CITY OF ALBUQUERQUE

Re: Candlelight Foothills Unit 1, SIA/Financial Guarantee Release
Engineer's Stamp dated 12-13-06 (J23-D3A)
Certification dated 9-24-07

RE: GRADING AND DRAINAGE PLAN CERTIFICATION FOR LOT 20-A,
CANDLELIGHT FOOTHILLS, UNIT 1 SUBDIVISION (J23 / D3A)

LOT 20			
GRADING AND DRAINAGE PLAN			
DRAWING: 200130-G&D.DWG	DRAWN BY: SHH	DATE: 10-14-01	SHEET # 1 OF 1

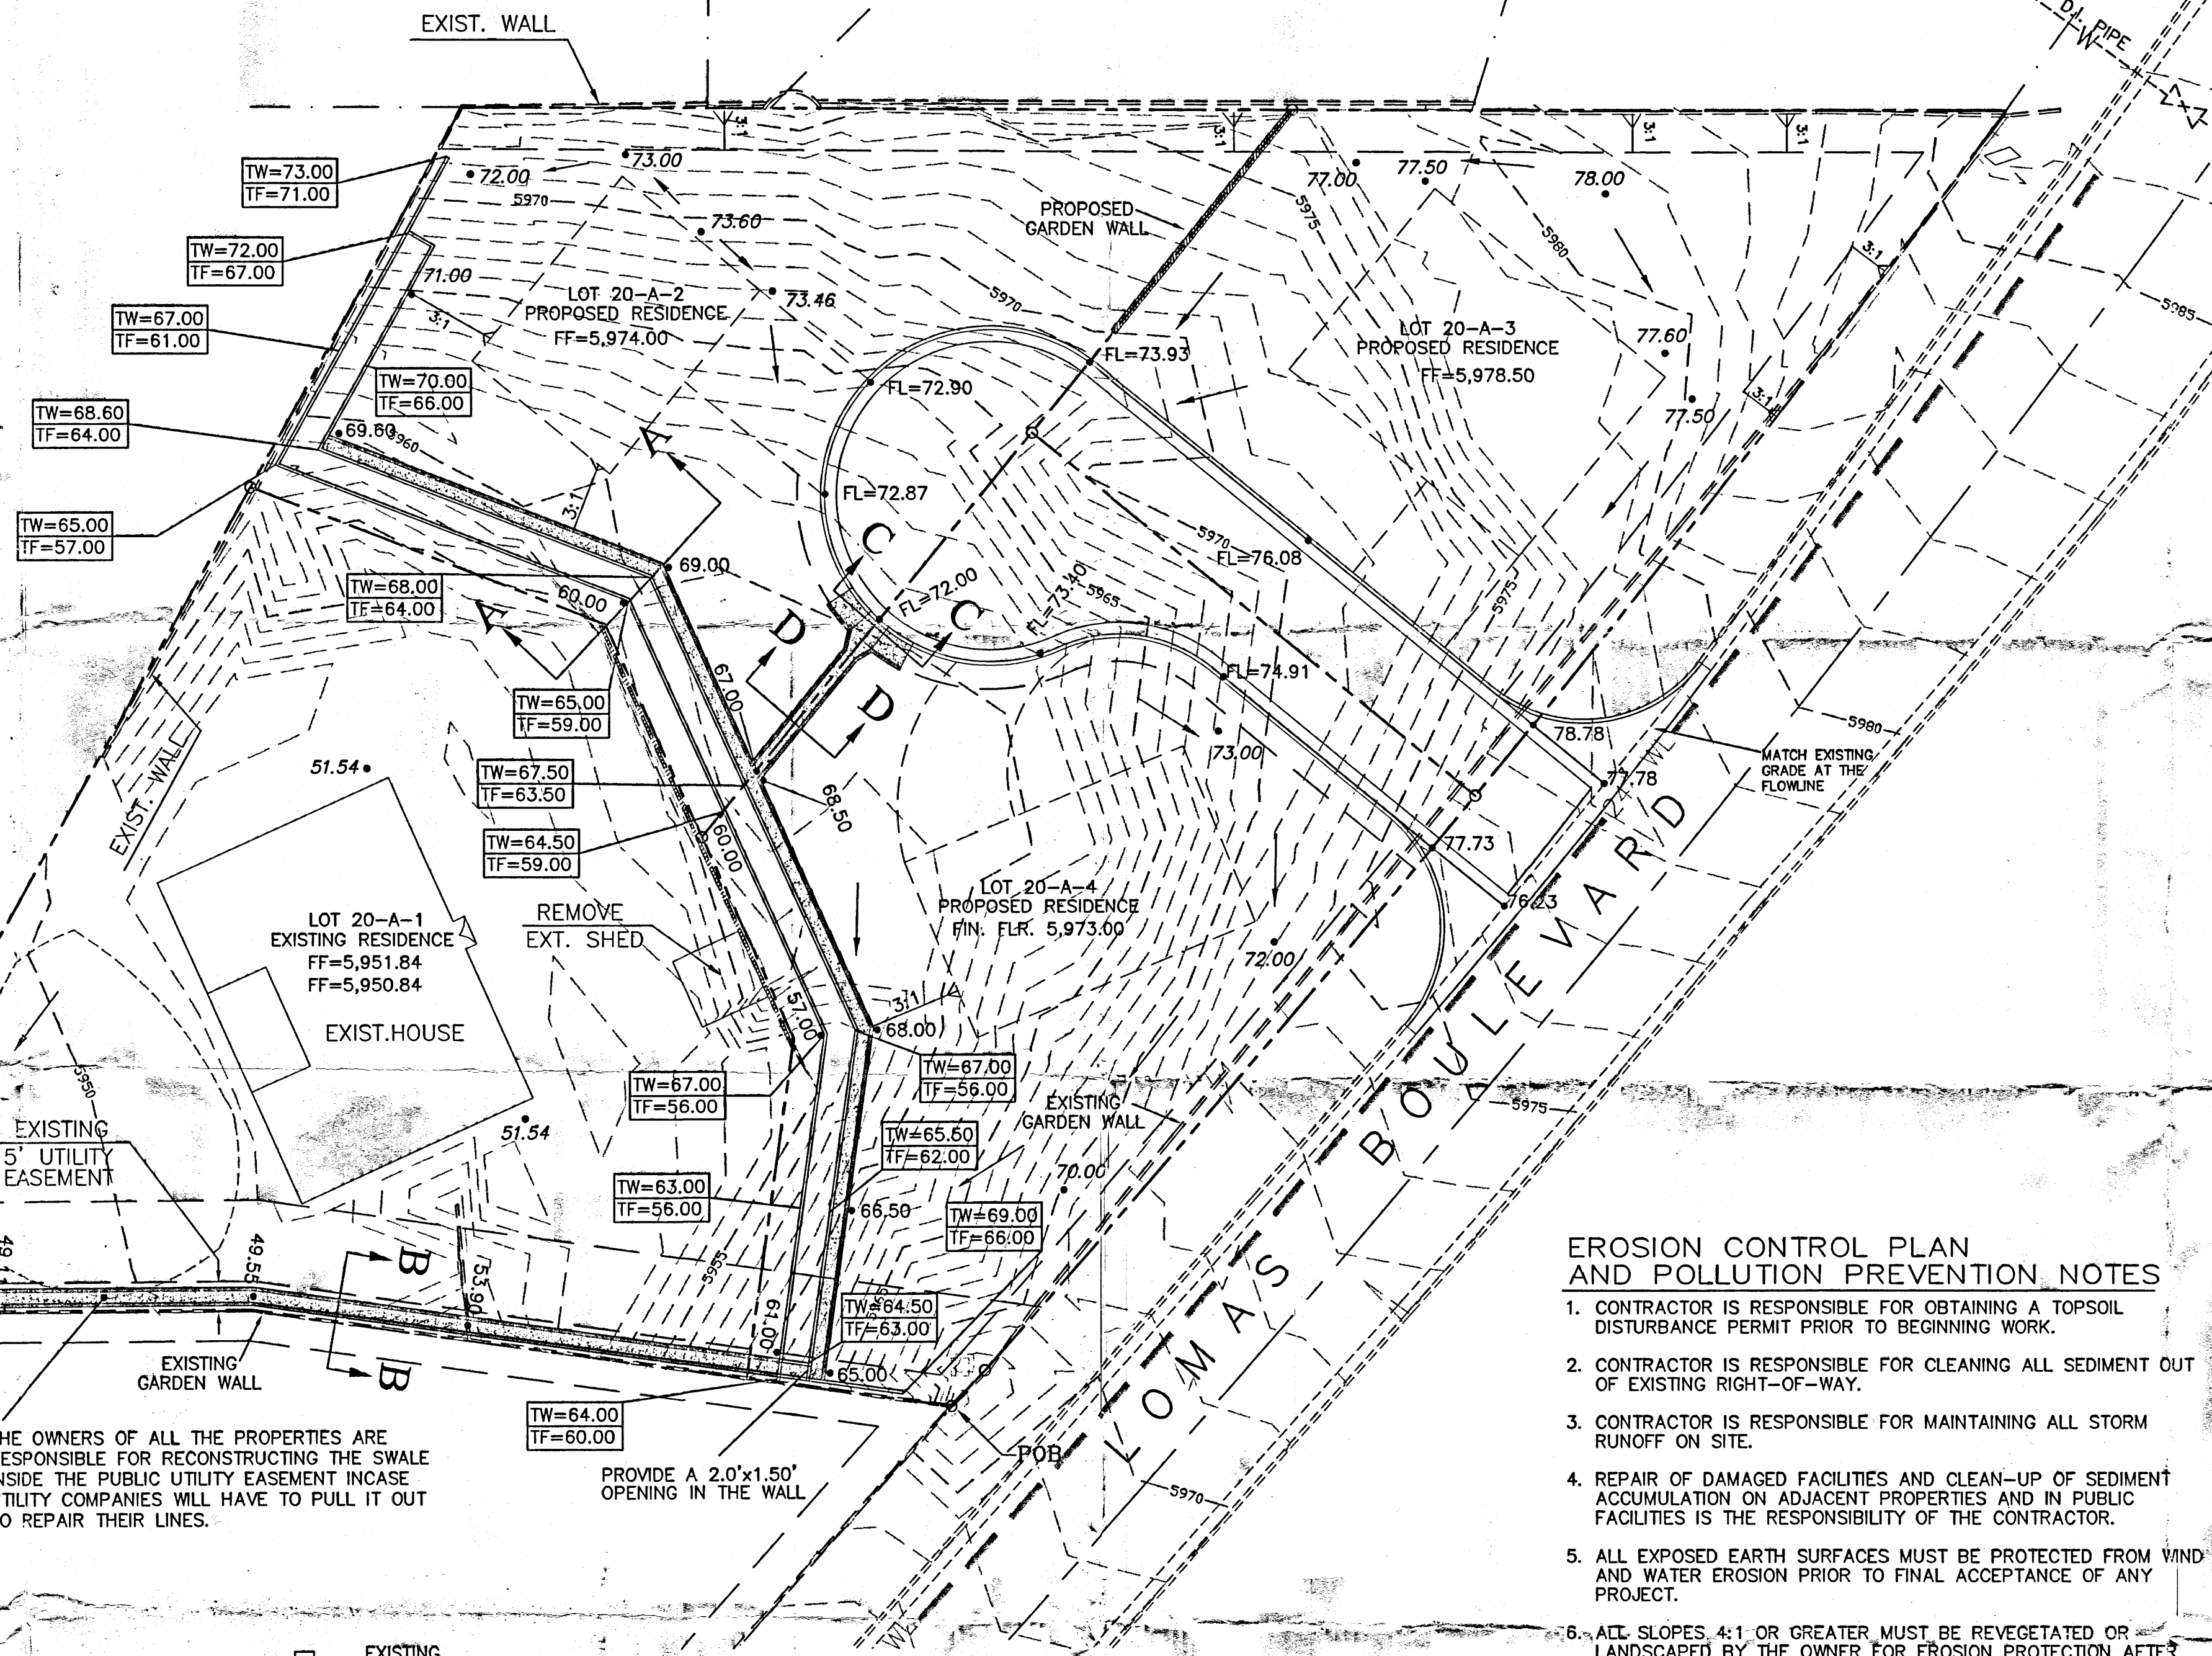
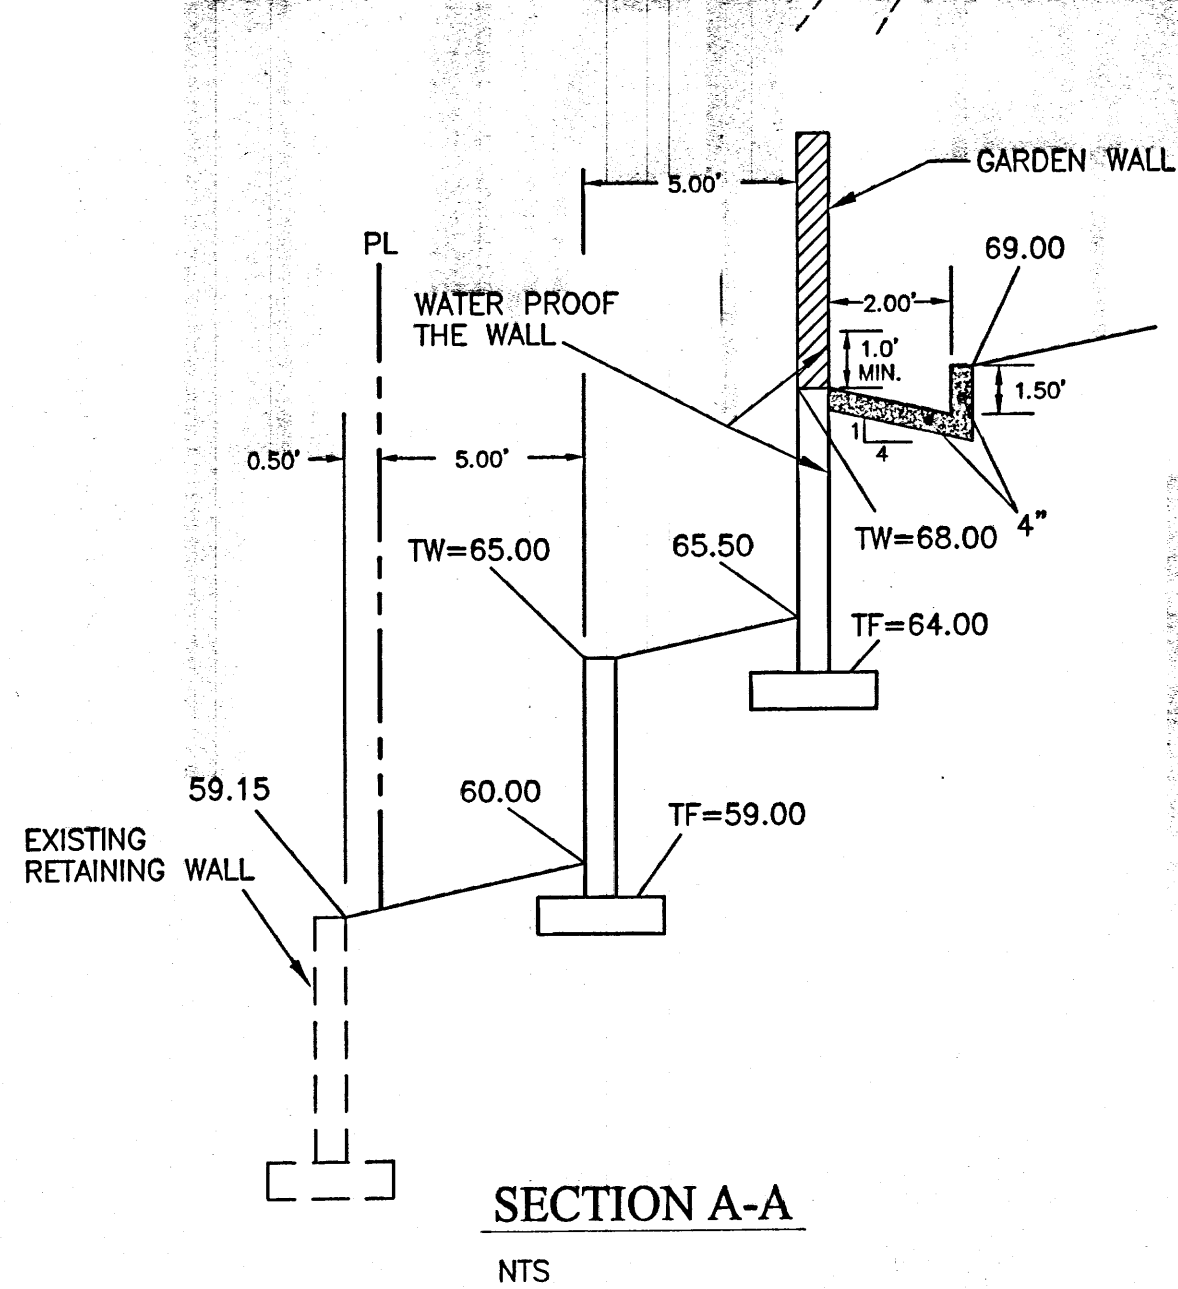
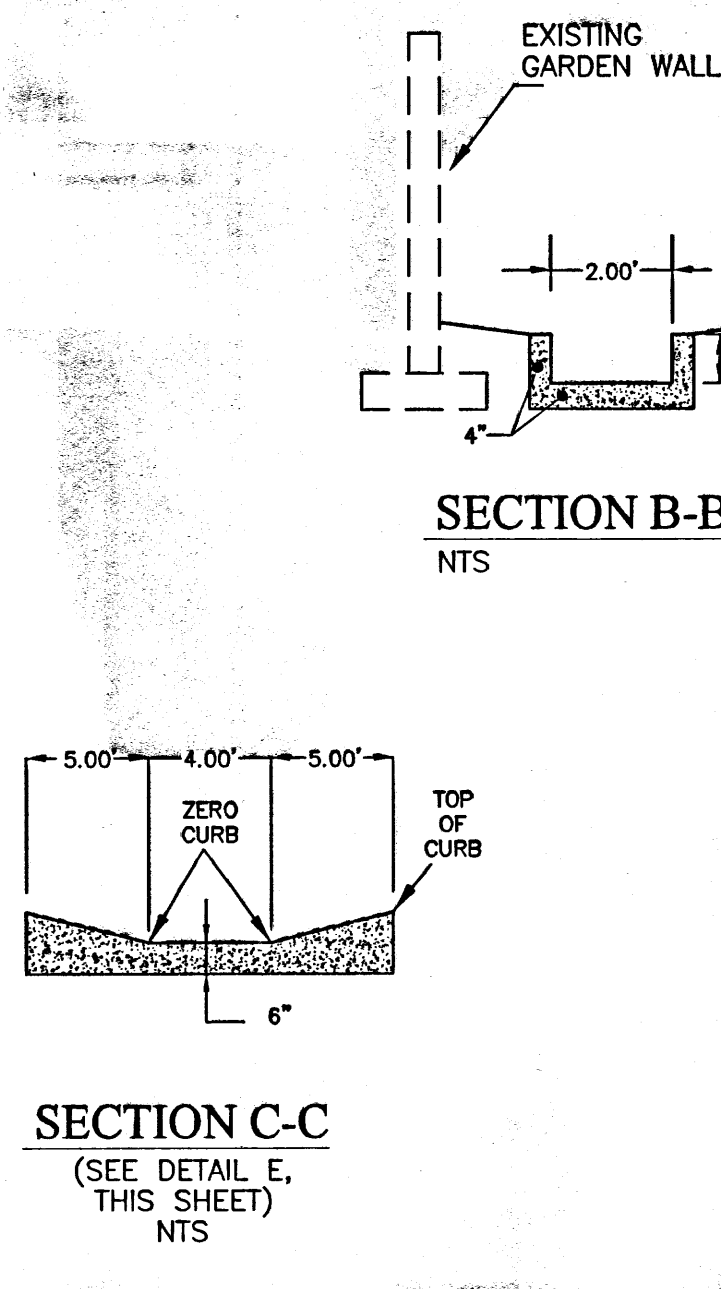
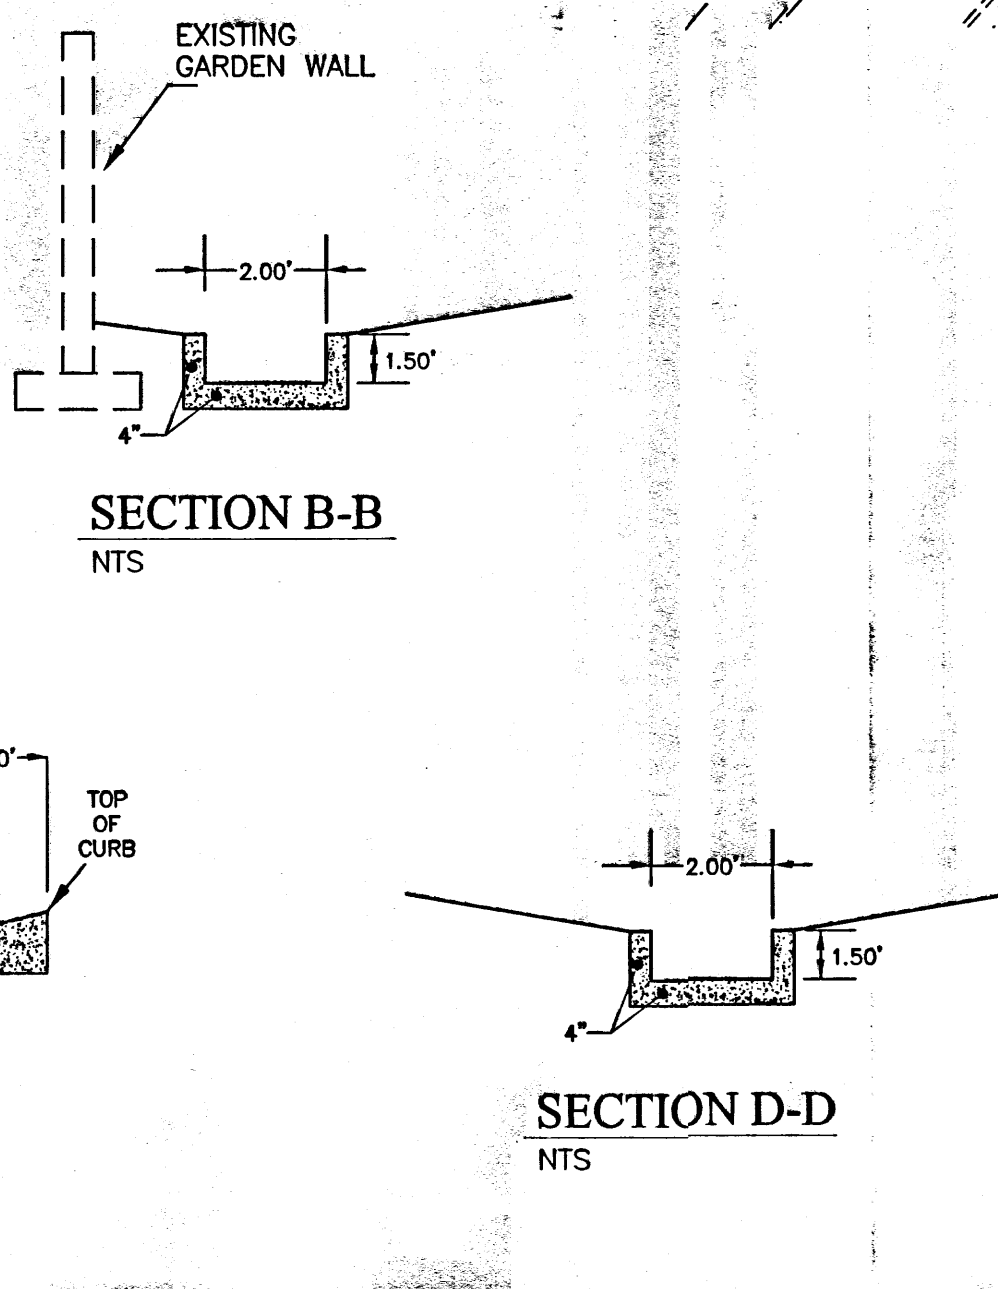
1. Please reverse the direction of the arrows on the section A-A symbol in the plan view.
2. For the Section A-A detail, show the property line. Dimension the property line and the new retaining wall from the existing retaining wall.

3. More on Section A-A: The plan view shows an existing garden wall symbol, but the section detail shows an existing retaining wall. I had to refer to the old Louis Gross plan to determine the intent in this area. Please clarify your plan.

4. At the westernmost corner of Lot 20-A-2, there is a gap with spot elevation 69.60. I assume this is an opening into the 2-foot wide concrete drainage rundown. Please call out the opening and width.

5. On the Section B-B detail, you show an existing garden wall. Show this on the plan.
6. In your submittal letter dated Dec. 7, 2001, you mention adding a note to the plan, stating that the owners of the properties are responsible for reconstructing the swale in the public utility easement. Please do add this note to the plan. Show the existing public utility easements on the plan.

7. Please review and re-write Erosion Control Plan and Pollution Prevention Plan Notes 5 and 6. Note 5 does not make sense. Note 6 is unclear. **When** must the disturbed areas be re-vegetated, and **by whom**?

- The concrete swale should extend to the curb and a sidewalk culvert installed. Also, please provide the thickness of all structural elements.
- The channel is to be in an existing 5' PUE. Are there any existing facilities there? Have the utilities been advised of this proposal?
- All private drainage easements should encompass the footing of the wall plus possible excavation requirements. You will need to show that a "garden wall is extended above the retaining wall.
- Please show that each lot will either drain to the private street or to the private easement with property walls or something similar.
